Comment re. AKPlanning's Supporting Statement: Plot 23 and No. 92 Lingards Road

It is important that application 2026/91657 is assessed as a whole. The application is not limited to the double garage. It also includes the new basement/lower level, changes to the driveway, changes to the raised patio, and changes to the lower-ground-floor kitchen arrangement. The impact on No.92 must therefore be assessed cumulatively, not by treating each change as isolated or minor.

This is a view up Lingards taken from the approximate position of the access to the new development and facing south.

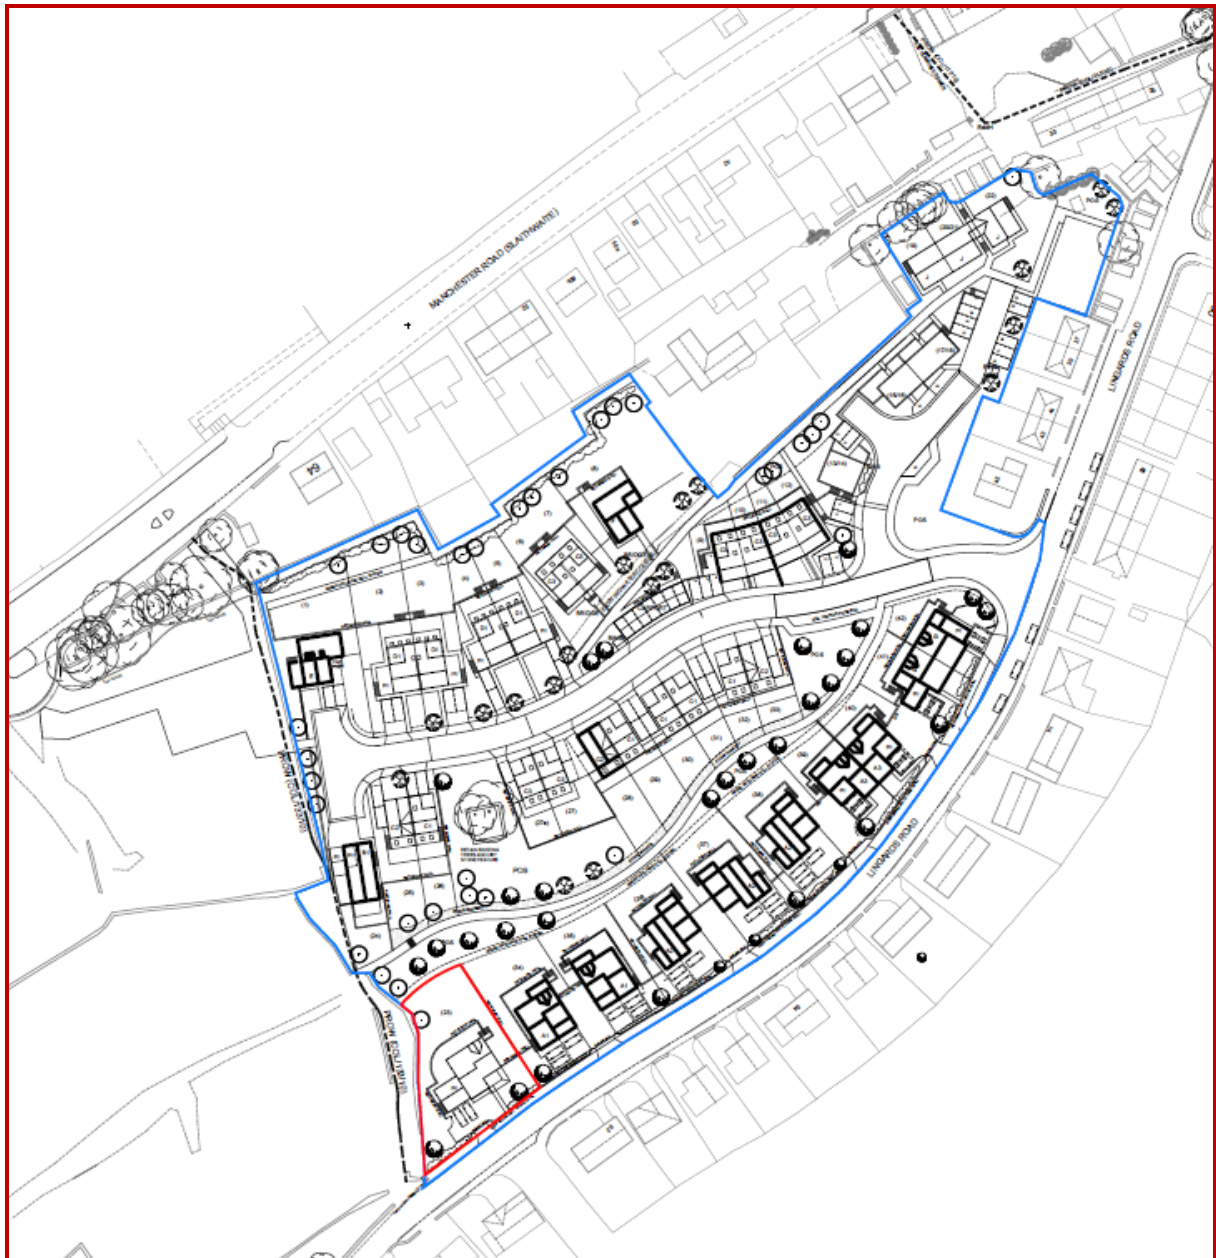
The photograph relied upon by AKPlanning appears to have been taken from some distance (approximately 48m) and does not provide a close, property-specific assessment of the relationship between Plot 23 and No. 92. The selected photograph (looking north east, not south) also appears to rely on a wider streetscene view, rather than the direct outlook from No. 92 towards Plot 23. The most prominent dwelling in the photograph does not sit opposite Lingards Fold, being situated further up Lingards Road.

That matters because No. 92 is angled slightly up the valley, meaning that the principal outlook from its front elevation windows is directed more towards Plot 23 than Plot 34. The hedge between No. 92 and No. 90 also affects the outlook from No. 92 and further focuses attention towards Plot 23. A general streetscene photograph cannot substitute for a property-specific assessment from No. 92.

The Council should therefore assess the impact from No. 92 itself, including the front elevation windows and front amenity area, rather than relying only on general photographs or broad descriptions of dwellings along Lingards Road.

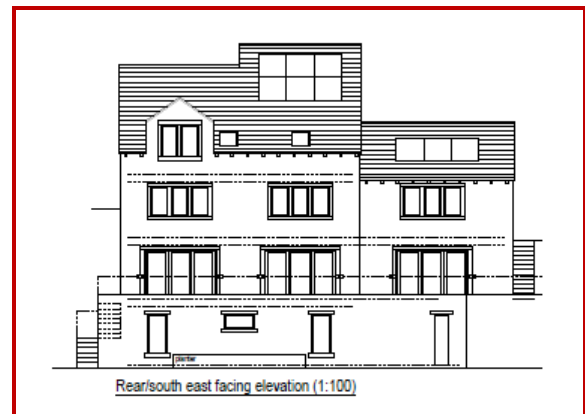
AKPlanning describes Plot 23 as being opposite "large detached dwellings". Dwellings meaning plural. That description is not accepted insofar as it relates to No. 92.

The description of the opposite properties as "large detached dwellings" risks materially mischaracterising No. 92 and therefore the planning assessment.
